Our Ref: R/2019/20/D  
File No: 2021/517328  
Your Ref: SSD-10384-Mod-1

**Request for Advice – SSD 10384 MOD 1 – Removal and replacement of 2 trees on Gloucester Walk**

Thank you for your correspondence dated 9 November 2021 inviting the City of Sydney Council (“the City”) to provide comments on the proposed modifications to the approved State Significant Development (SSD) application for the adaptive reuse, alterations and additions to the Sirius building.

**Typical Wall section South of Grid 108.5 at Tree 50**

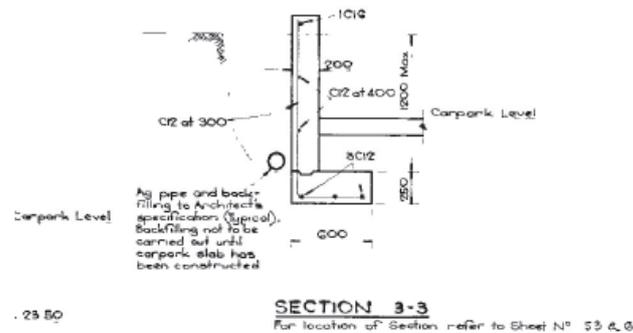
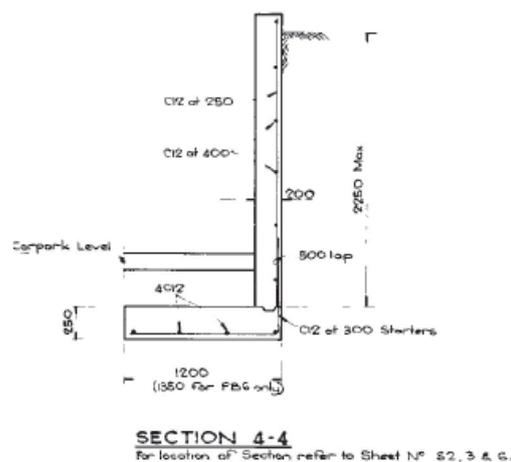
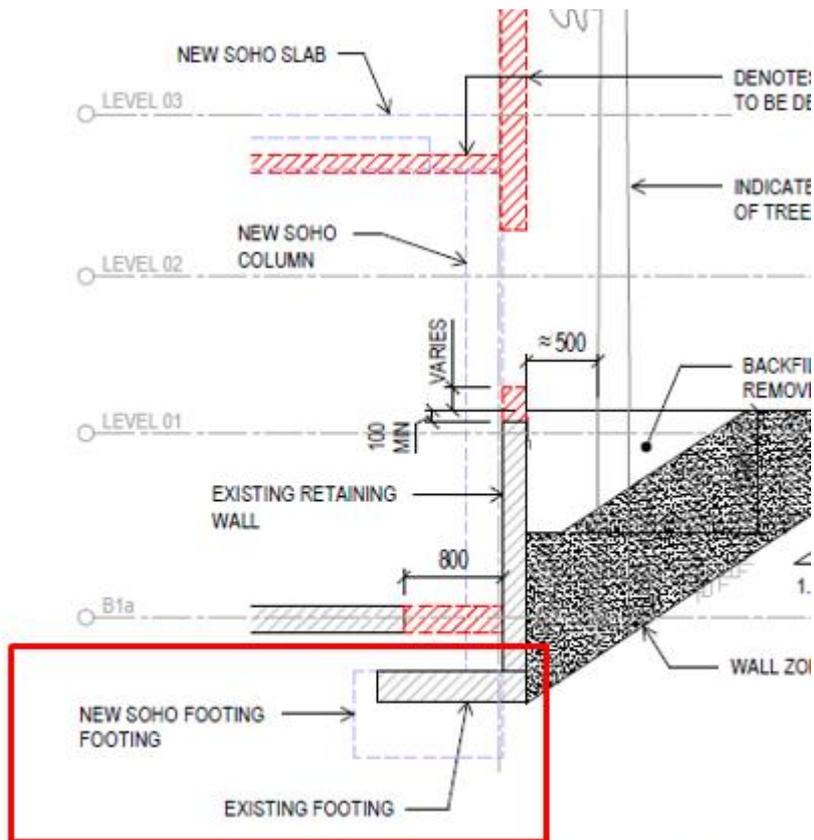
The proposed modification now seeks the removal of Trees 50 and 51 to allow the existing retaining wall and material with the structural root zone (SRZ) of these trees to be removed. Based on the advice contained in the submitted structural engineers report prepared by SCP dated 21 September 2021, it understood that the existing retaining wall and footings do not comply with current standards and would require enlargement to comply.

It is noted that the pad footings for the future SoHo structure and podium above will require the demolition of the existing retaining wall footings, however, the proposed pad footing will be located within the existing building footprint, some distance from the trees. Further, the consulting Arborist has not provided any recommendations that would allow

Overall, the removal of these high landscape value trees is not supported by the City and modifications to the proposed design are recommended that would involve typical work methods (i.e. tree sensitive methodologies to retain the existing soil/retaining wall) to allow the trees to be retained.

L-DA-09

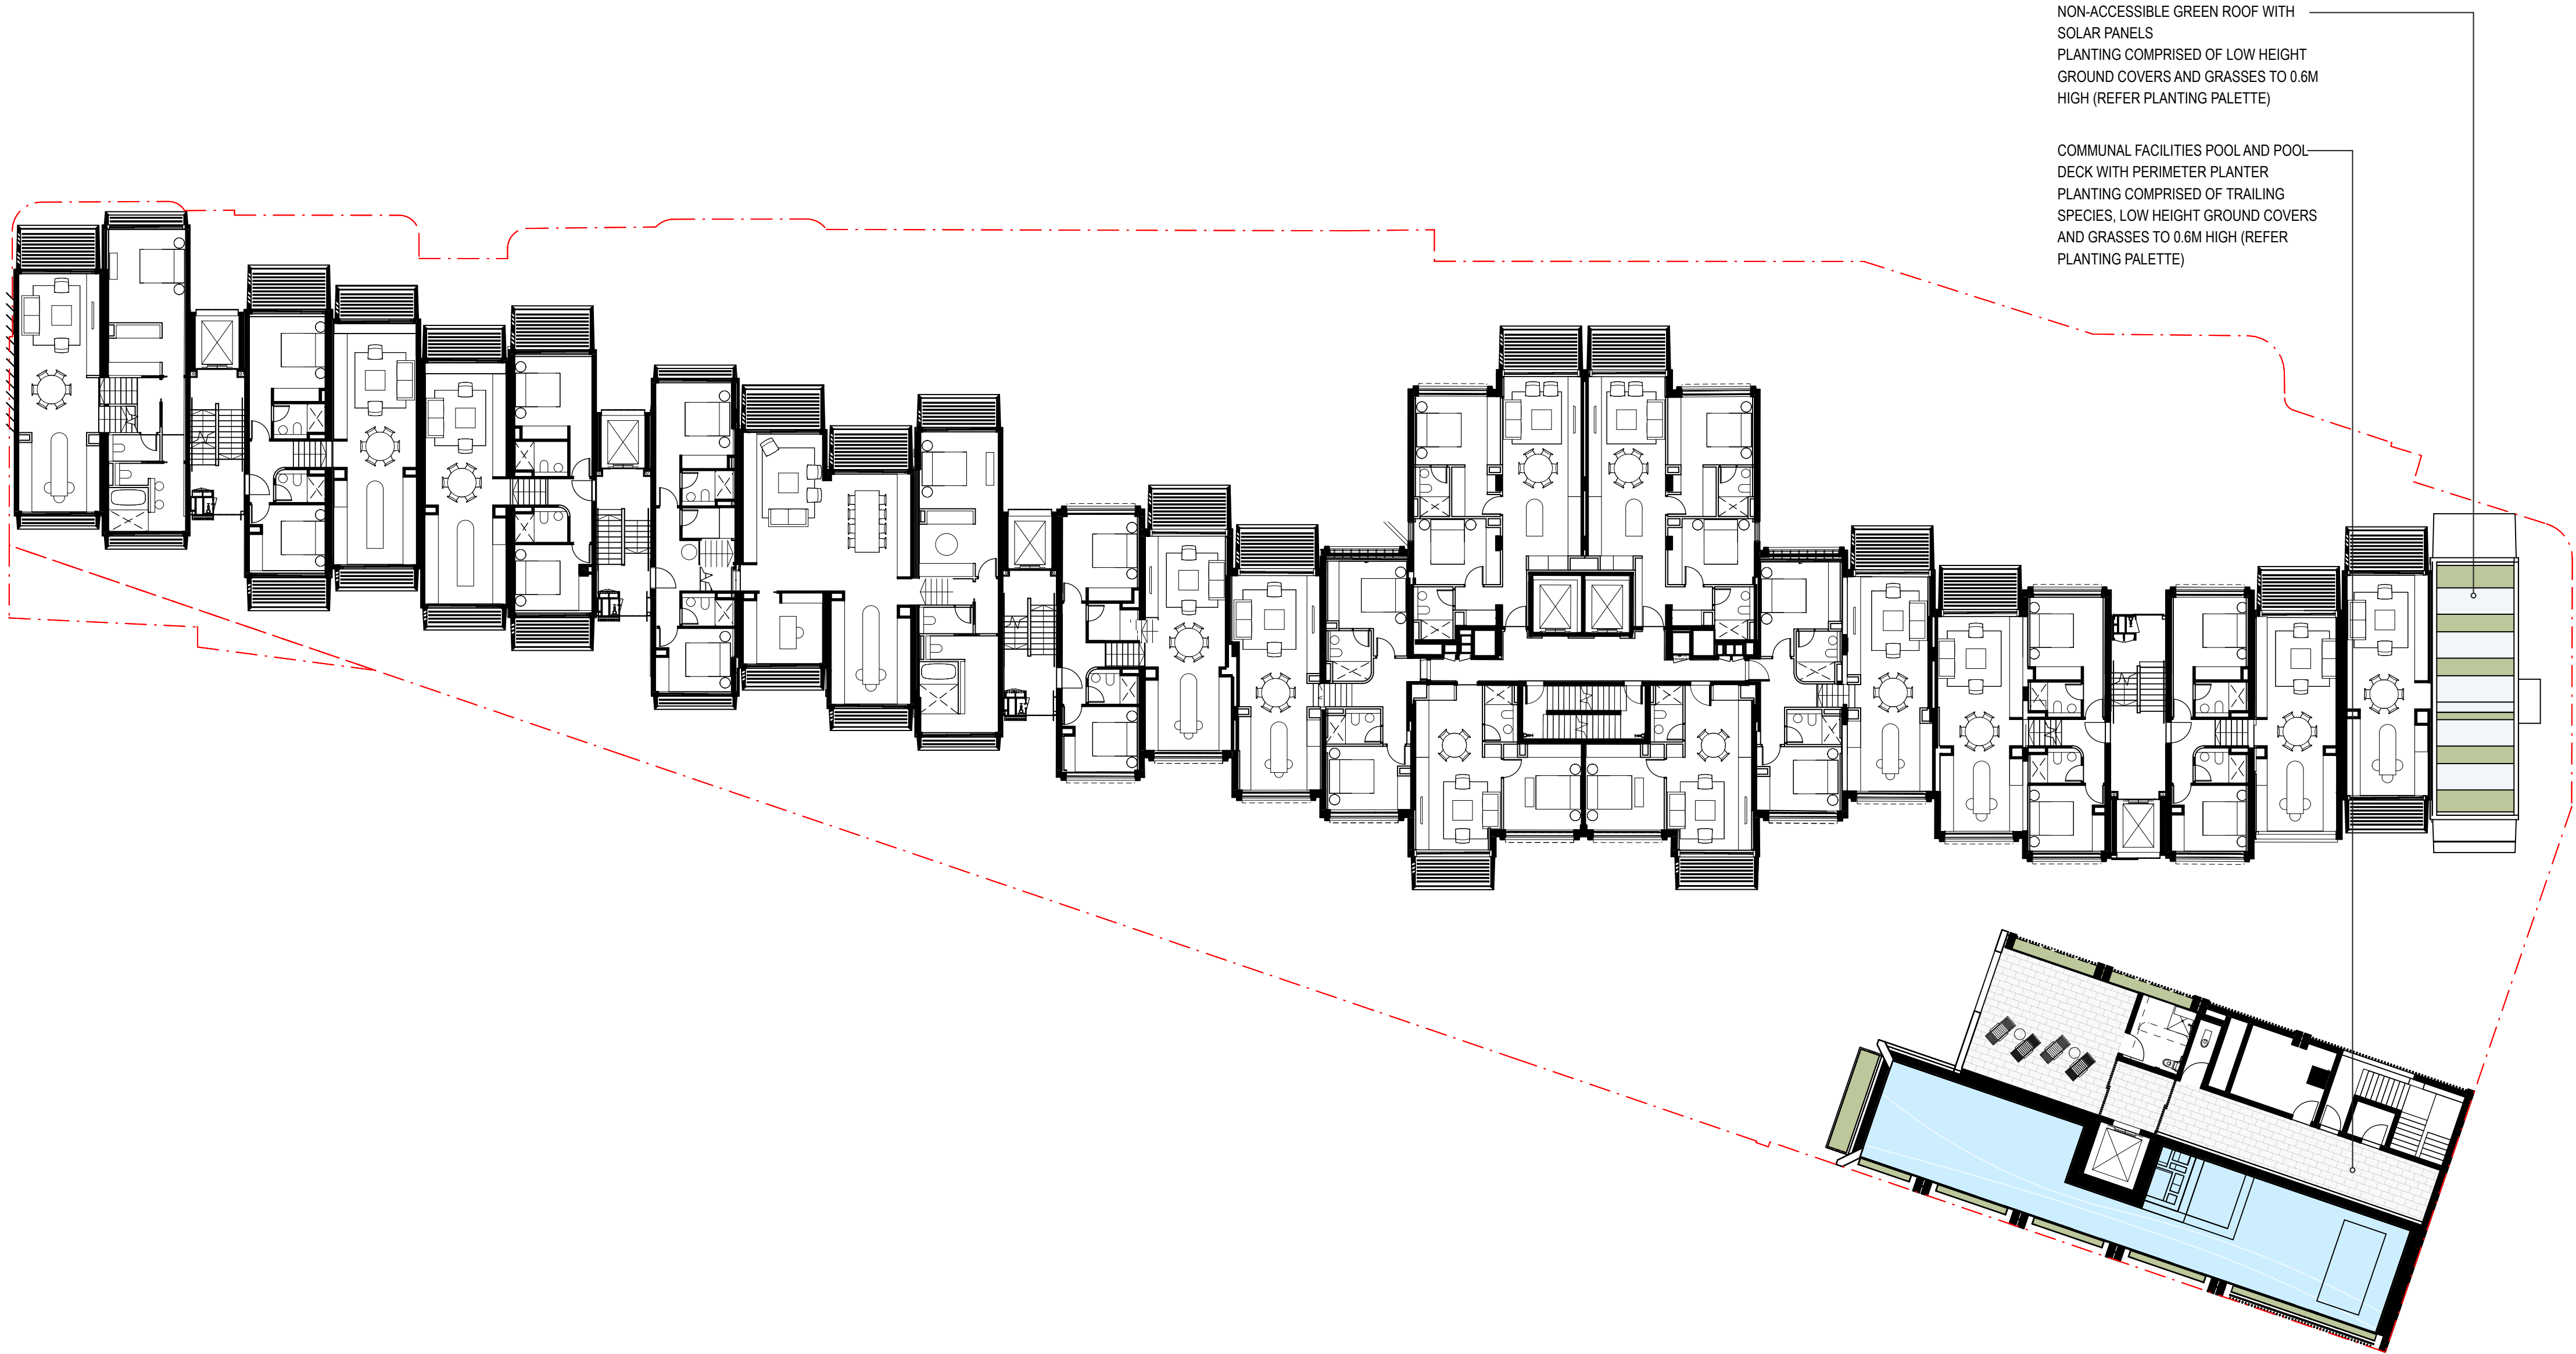
Separate to the City's objection to the proposed removal of Trees 50 and 51, the following comments are provided regarding landscaping. The amended Landscape Plans prepared by 360 Degrees dated 29 October 2021 'Revision H' highlights the replacement planting of Trees 50 and 51 as a recent amendment, however, the proposed species has also changed. As an example, an *Ulmus parvifolia* 'Yarralumla' (Chinese Weeping Elm) has been changed to three *Livistona australis* (Cabbage Palm).

Some other tree species have been amended in accordance with previous recommendations, however, it is recommended that a complete detailed and scaled landscape plan, prepared by a qualified landscape architect or landscape designer be submitted for further consideration. The landscape plan should include:

- (i) Details of earthworks and soil depths including mounding and retaining walls and planter boxes (if applicable);
- (ii) Location, numbers, type and supply of plant species, with reference to the relevant Australian Standard;
- (iii) Details of planting procedure and maintenance;
- (iv) Details of drainage, waterproofing and watering systems.
